CITY OF ALBUQUERQUE

**Re: Bella Vista Assisted Living
13101 Constitution NE
30-Day Temporary Certificate of Occupancy- Transportation Development**
Architect's Stamp dated 06-05-15(J22D067)
Certification dated 10-17-16

CA-1.0

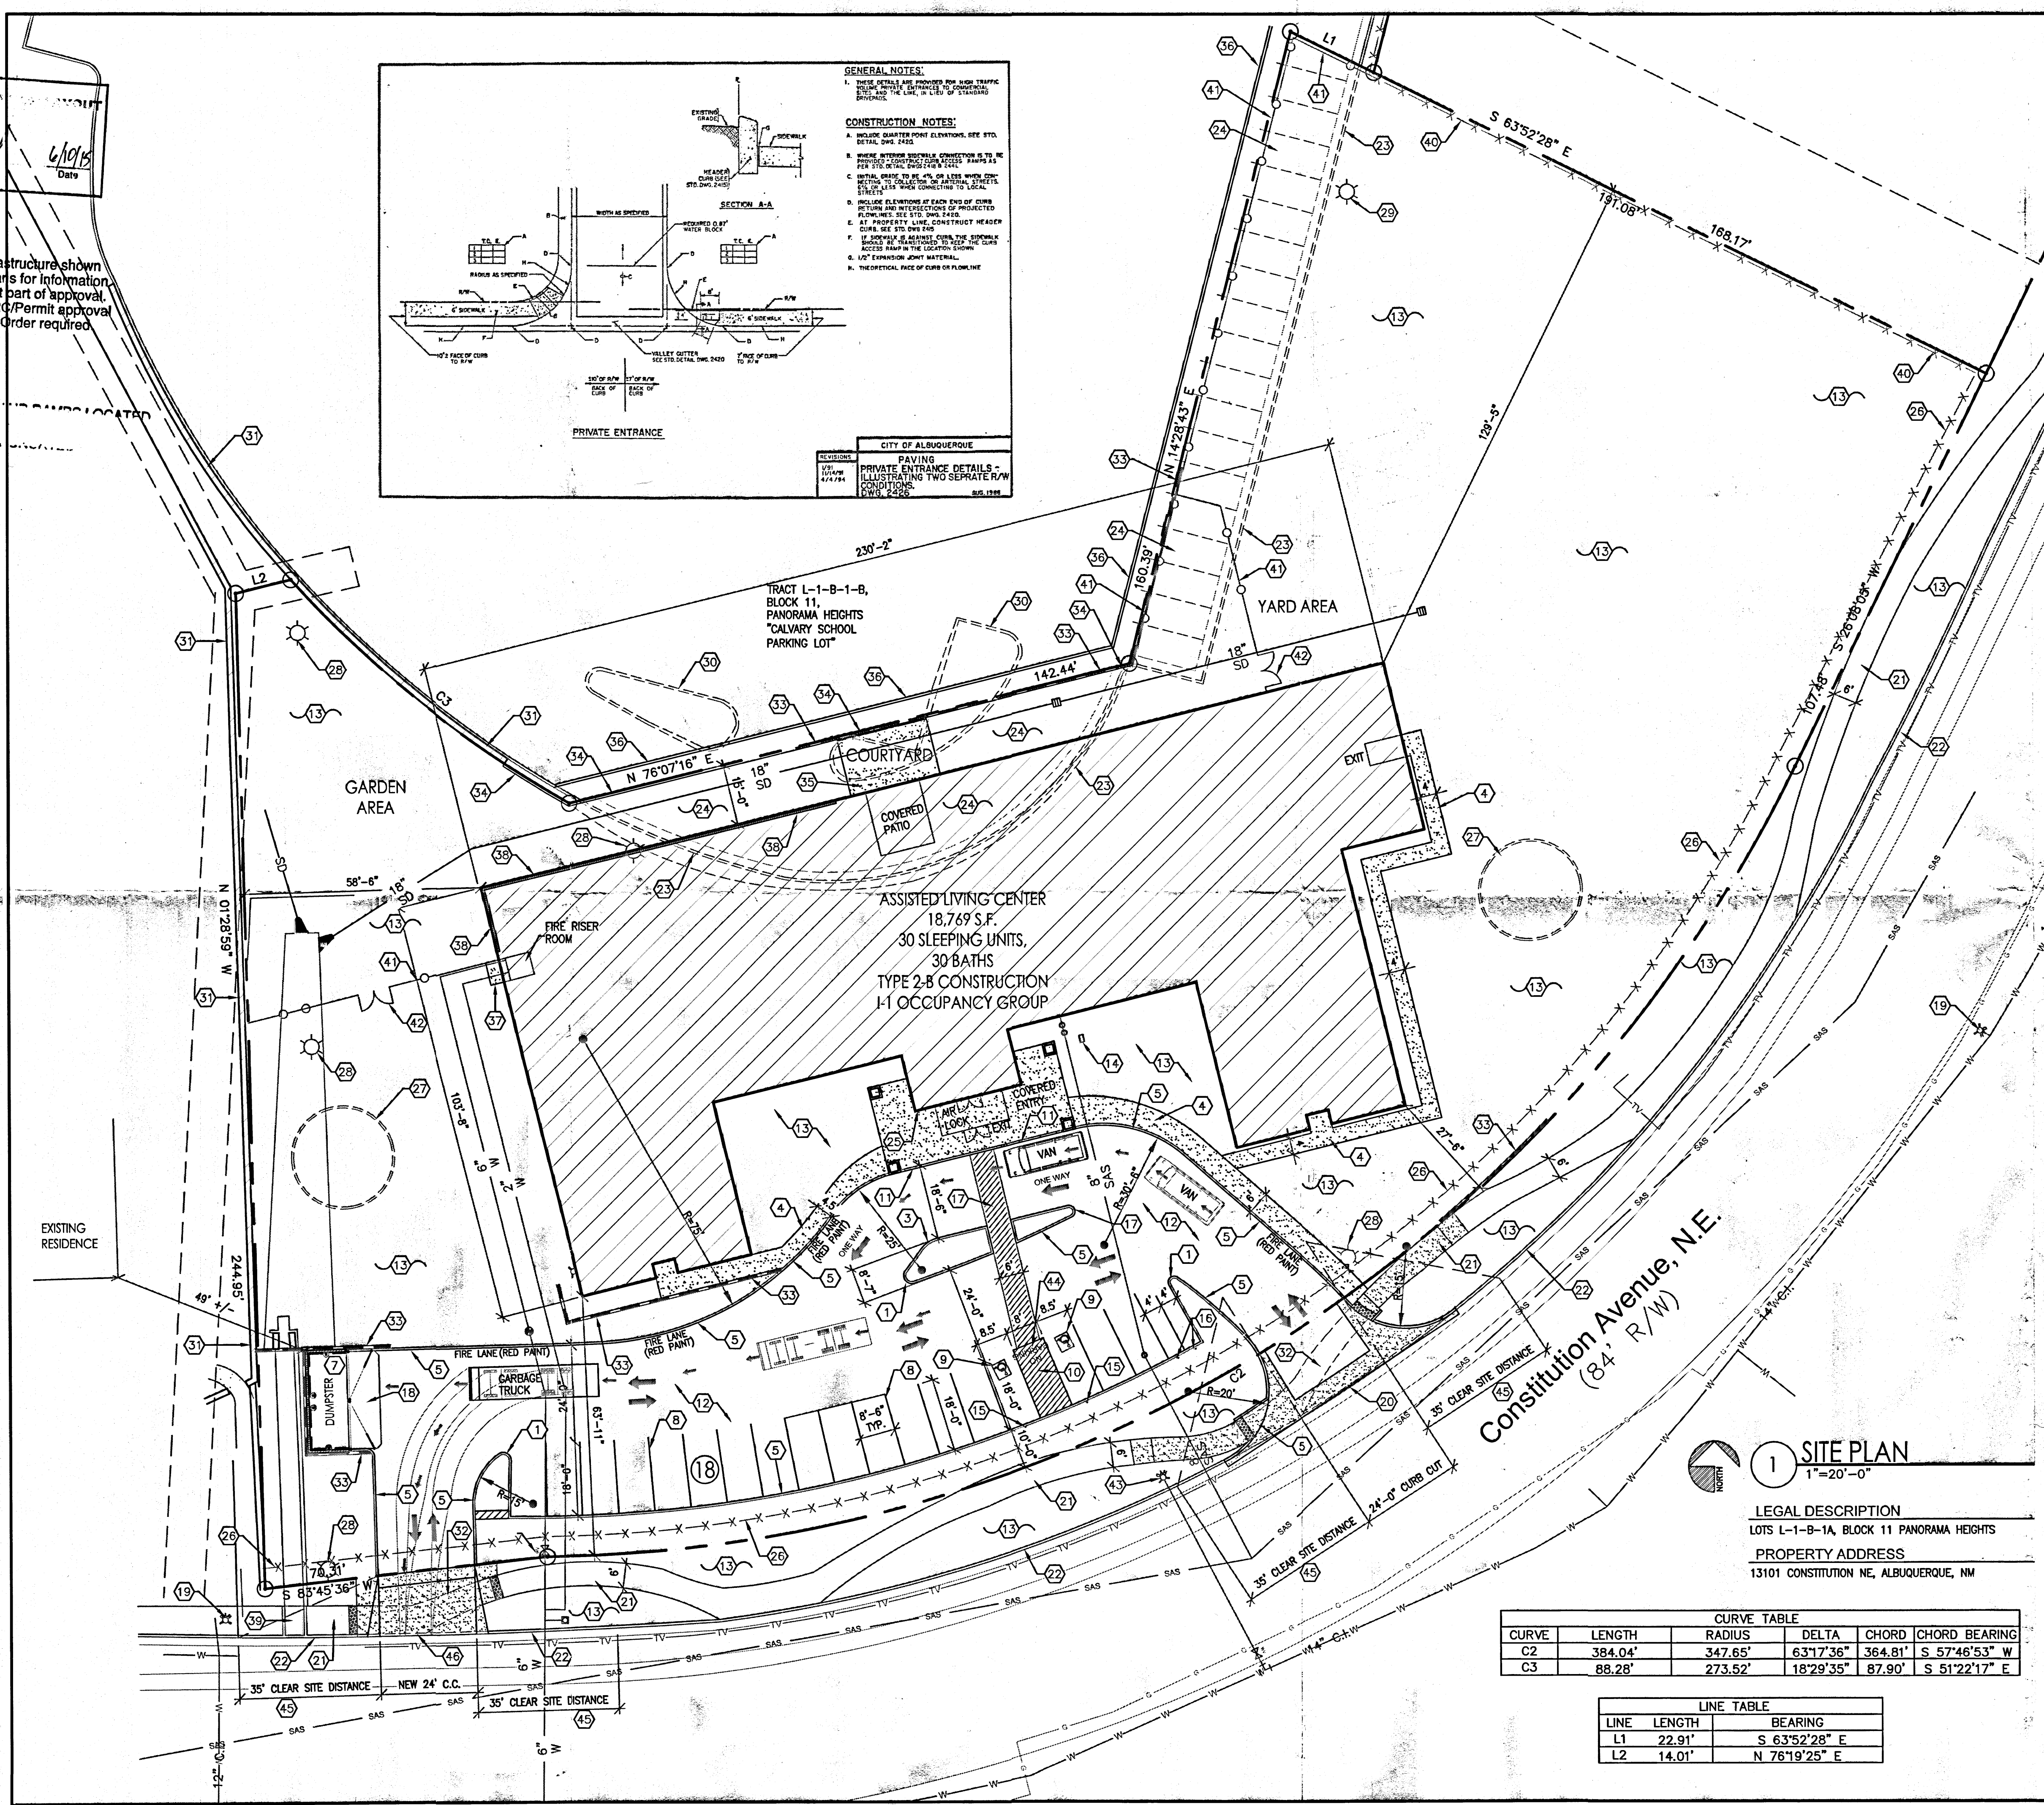
1. Truncated domes must be placed on the West drive pad within the City of Albuquerque right-of-way.
